From: Amanda Scholes on behalf of Planning.Responses
Sent: 20 October 2017 13:13
To: Planning Scanning
Subject: FW: Saltbox, Bognor Regis - Heads of Terms

Sent: 20 October 2017 11:35
To: Michael Eastham
Cc: Arfon Hughes
Subject: Re: Saltbox, Bognor Regis - Heads of Terms

In Nia's absence, there are just two design details that have arisen regarding the Unit 2 Warehouse:

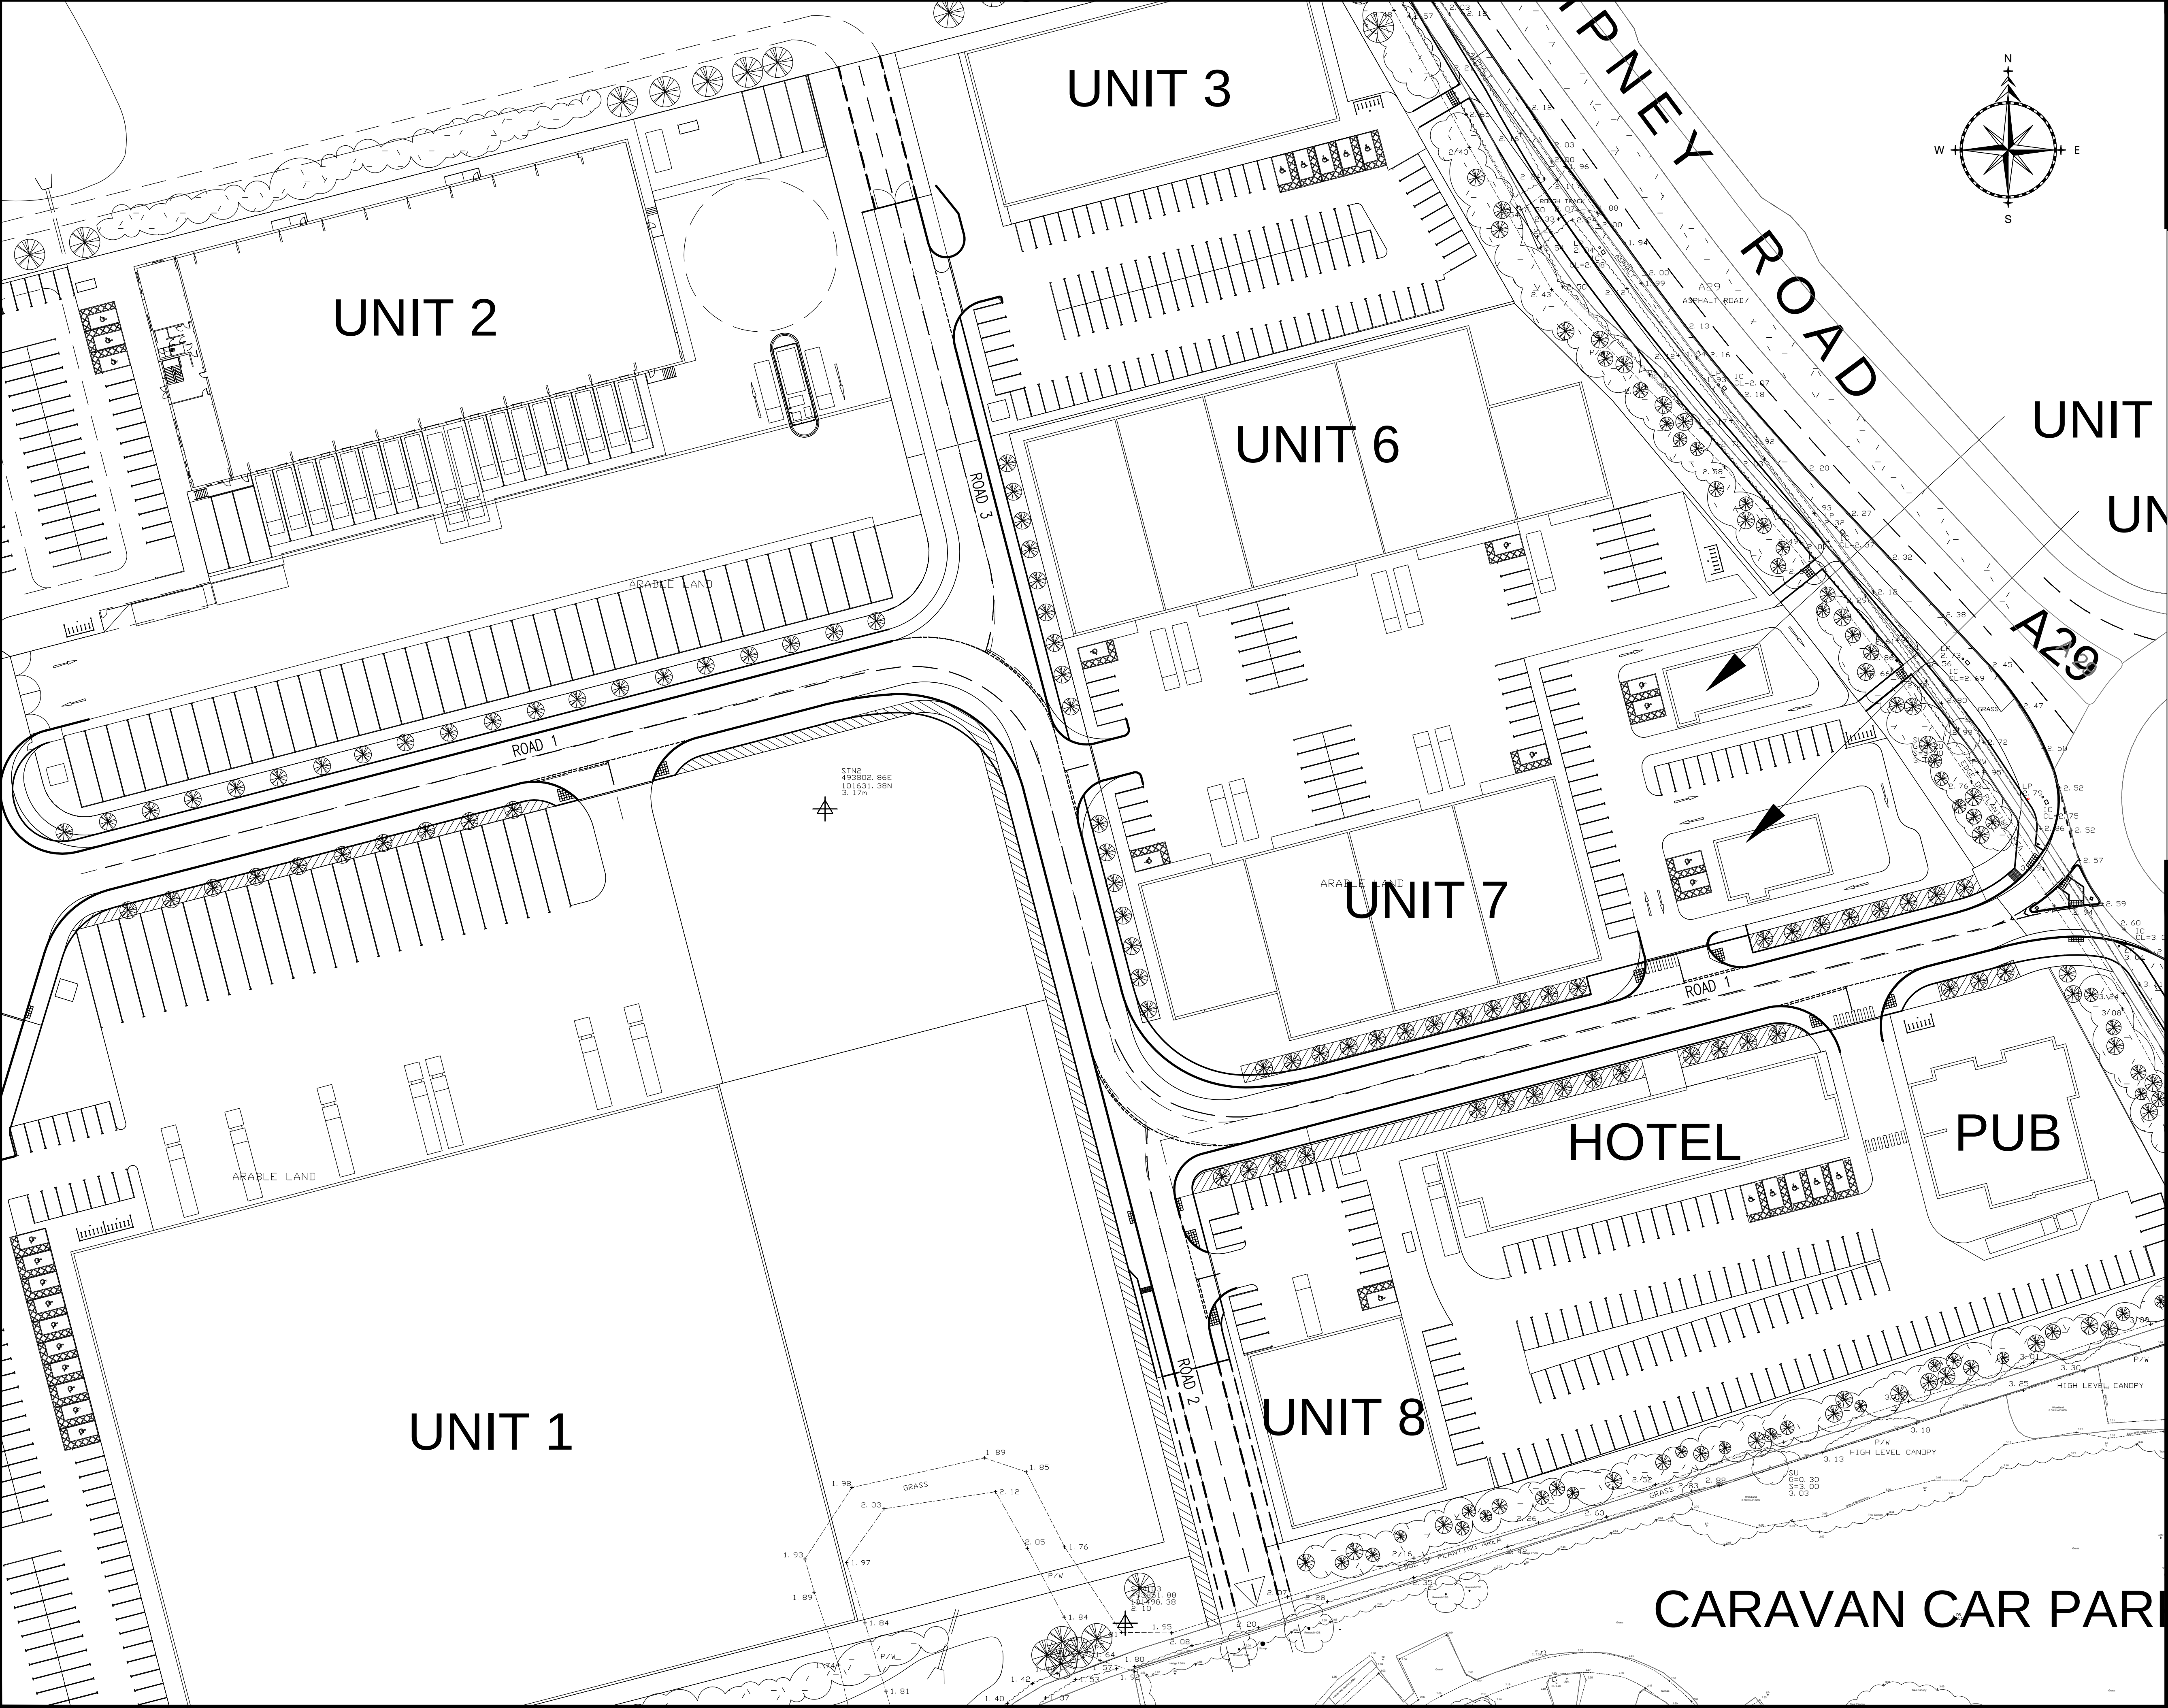
Michael, just to conclude matters, I would confirm that all outstanding matters have now been addressed. In saying this, I can't see a copy of the drawing showing the revised spine road arrangement (drawing no. H1194-201, dated 22nd September 2017) on the planning file. I presume this has been submitted to you and will form part of the package of approved drawings.

No part of the development shall be first occupied until such time as the vehicular access onto A259 Felpham Relief Road Roundabout has been constructed in accordance with the details indicatively shown on drawing no. H1194-201.

Please find attached a copy of H1194-200 Rev A which was amended to address comments from WSCC regarding the width of the estate road which we adjusted to allow two HGV's to pass without conflict on the bends.
